2023/0991

Proposed dormer bungalow

Land at Beechfield Close, Bolton Upon Dearne, Rotherham, S63 8EY

SITE LAYOUT PLAN

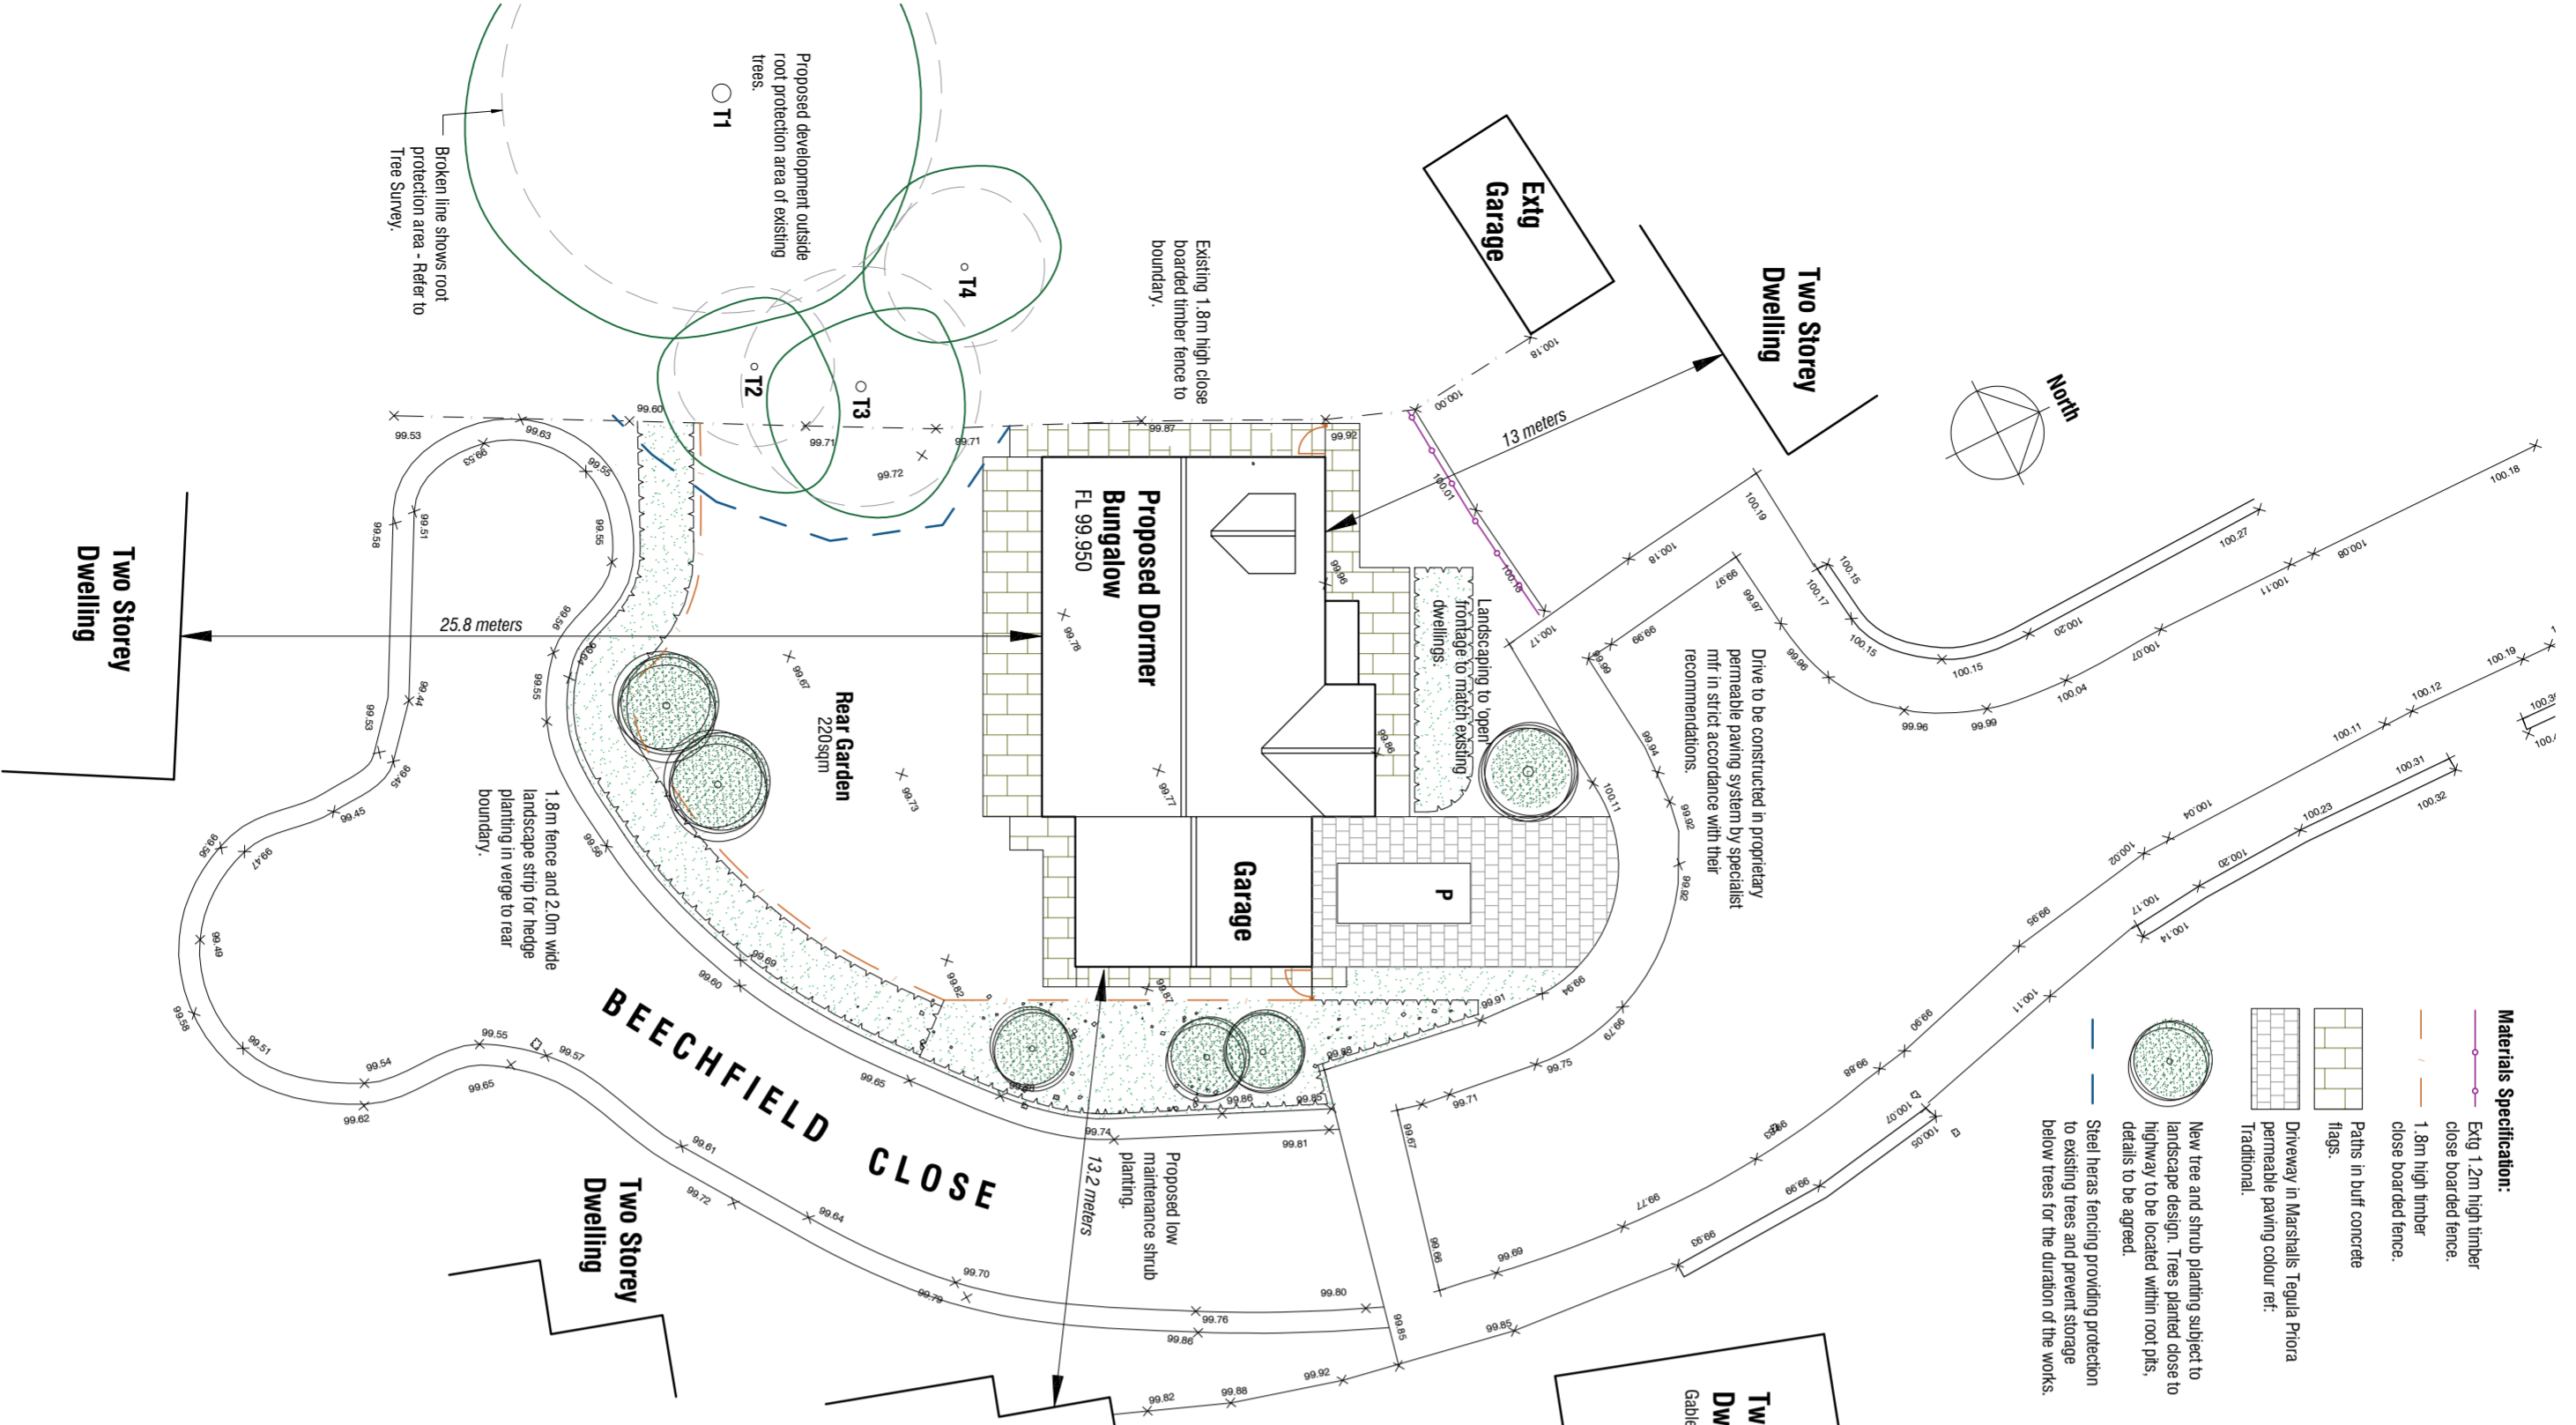
Given that there are trees set on the adjacent land, a Tree Survey has been provided to assess the impact of the proposal upon the root protection areas of adjacent trees. The plans show indicative landscaping to the eastern boundary, however no firm details have been provided in terms of the landscaping/boundary treatment proposed.

It can be seen from the submitted plans that the layout includes off-street parking provision for two vehicles, one vehicle being accommodated on the driveway and the second within the garage; the garage is of ample size and has internal dimensions suitable for vehicles of wheelchair users.

Vehicular access to the site is proposed to be in the same location as an existing dropped kerb access which appears to have been put in place to allow equipment (ride-on mower for example) to safely access the plot of land for maintenance purposes. As such, the length of dropped kerb is currently quite short and will therefore need to be widened if it is to be suitable for the use of regular sized vehicles.

The proposed driveway is of sufficient width to provide the required 2m x 2m pedestrian visibility splays and the proposed shrubbery/hedge and wooden fencing along the site boundary is acceptable in terms of sight lines/forward visibility.'

Proposed materials, landscaping and boundary treatments shall be conditioned to be submitted upon commencement of development. The proposal is considered to be acceptable in terms of design and impact upon the street scene in accordance with policy D1 of the Local Plan.

South West Elevation
1:100

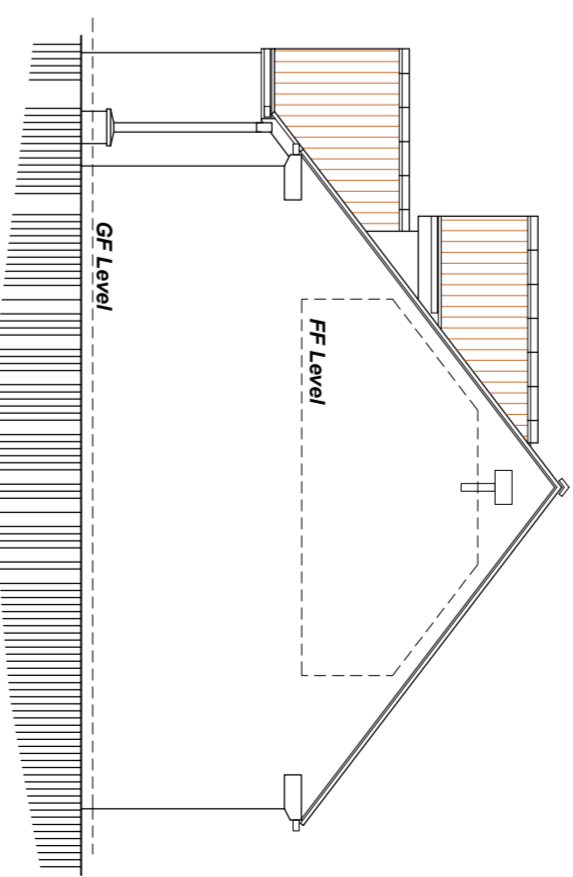
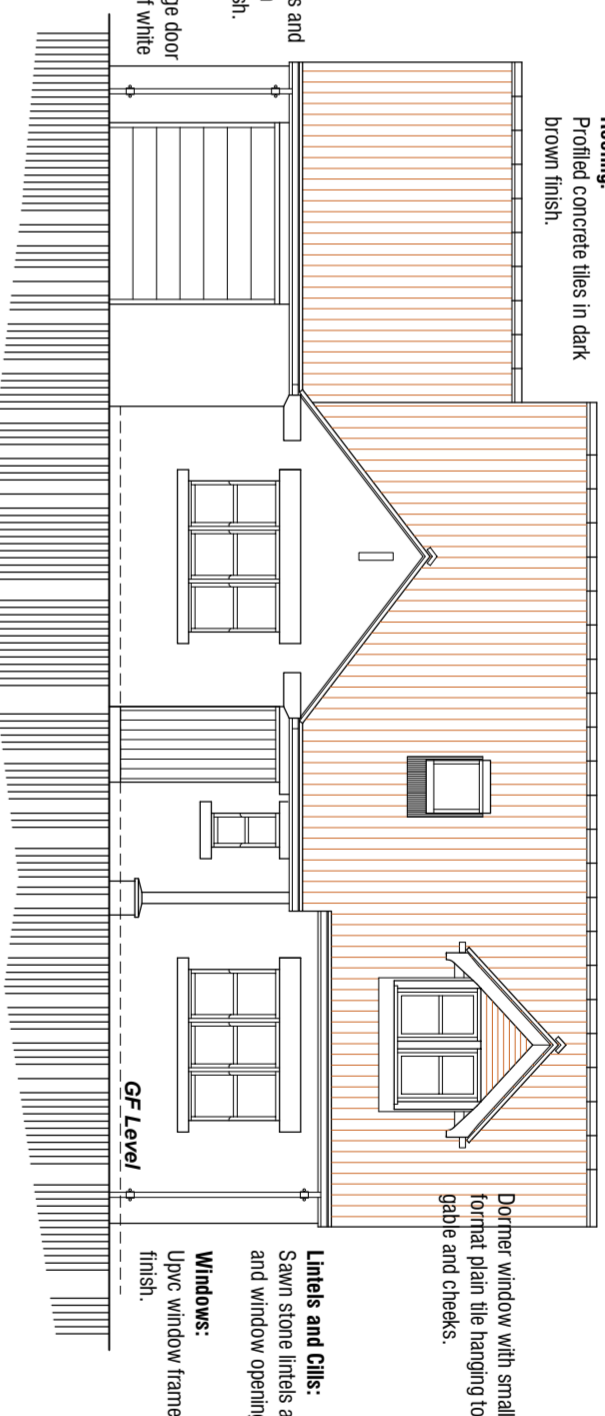
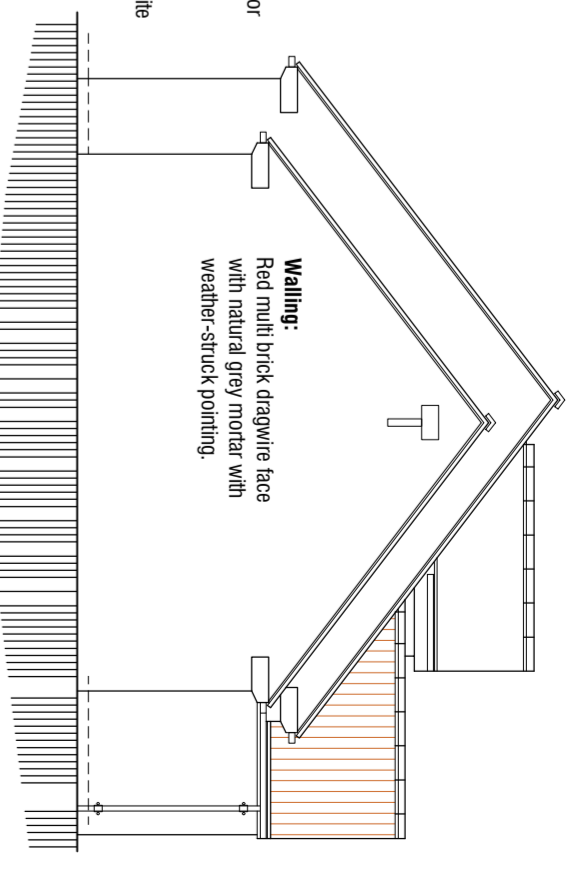
In terms of design and siting, the property has been designed so that it faces to the north and would have an active frontage onto Beechfield Close, with shrubs planted to the eastern boundary to soften the site. In terms of scale, although the surrounding houses are two storey detached, given that the site is in a central location within the cul-de-sac, therefore a two storey dwelling may appear prominent on this site, as a result the agent has designed a dwelling which is single storey with rooms within the roof space. The development of the site for a bungalow is considered to be acceptable as there are a number of different house types along the street, some of which have side elements which incorporate dormer windows. The style and design of the dwelling matches the details of the adjacent dwellings and would be

constructed of materials to match, therefore would not appear incongruous within the street scene. The use of dormer windows can be seen within the adjacent development and the dormer is designed with a pitched roof which is acceptable.
